**WELWYN HATFIELD BOROUGH COUNCIL
EXECUTIVE DIRECTOR - PLANNING, PUBLIC PROTECTION AND GOVERNANCE**

Application No: 6/2022/0949/HOUSE
Location: 21 Kingswell Ride Cuffley Potters Bar Hertfordshire EN6 4LH
Proposal: Alterations to fenestration, part conversion of front hipped roof to gable roof, erection of rear roof extension with conversion of rear hipped roof to gable and insertion of two side dormers, erection of single storey rear extension with roof terrace over rear ground floor flat roof, and raised rear patio
Officer: Ms Kirsty Shirley

6/2022/0949/HOUSE

Project No.	Drawing No.	Revision
220201-01	A108	A

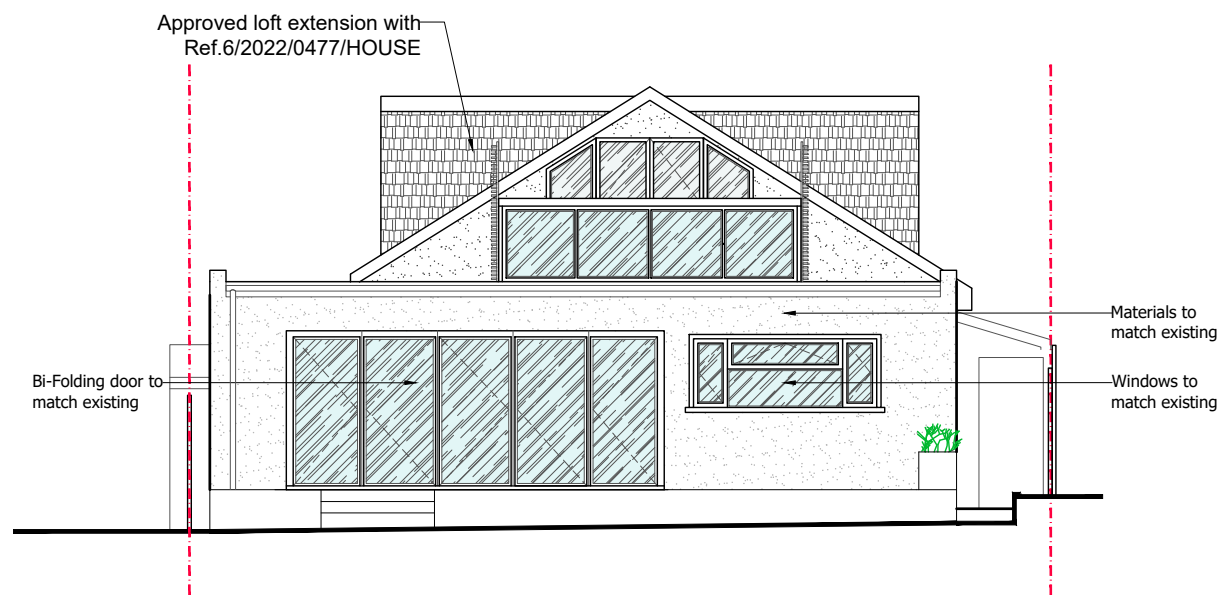
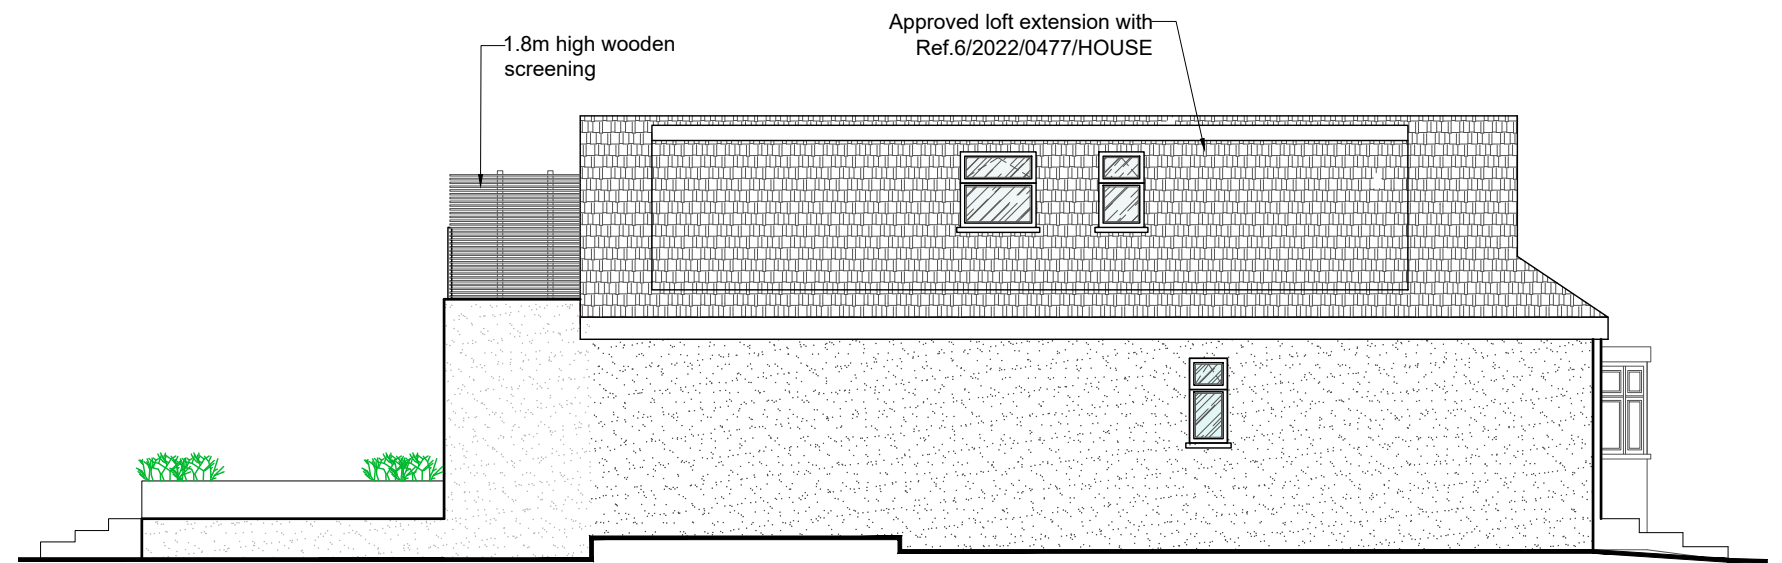
In regards to privacy, the proposed first floor terrace would feature 1.8m wooden screening either side of the terrace to protect the privacy of the occupiers of Nos 19 and 23. It is considered that the height and material of the screening would prevent any undue overlooking towards Nos 19 and 23, and details of the screening can be secured by condition.

2. No development above ground level in any phase of the development shall take place until full details on a suitably scaled plan of the proposed terrace screening, shown on approved drawing A108 A, has been submitted to and approved in writing by the Local Planning Authority. Subsequently, The development shall not be carried out other than in accordance with the approved details.
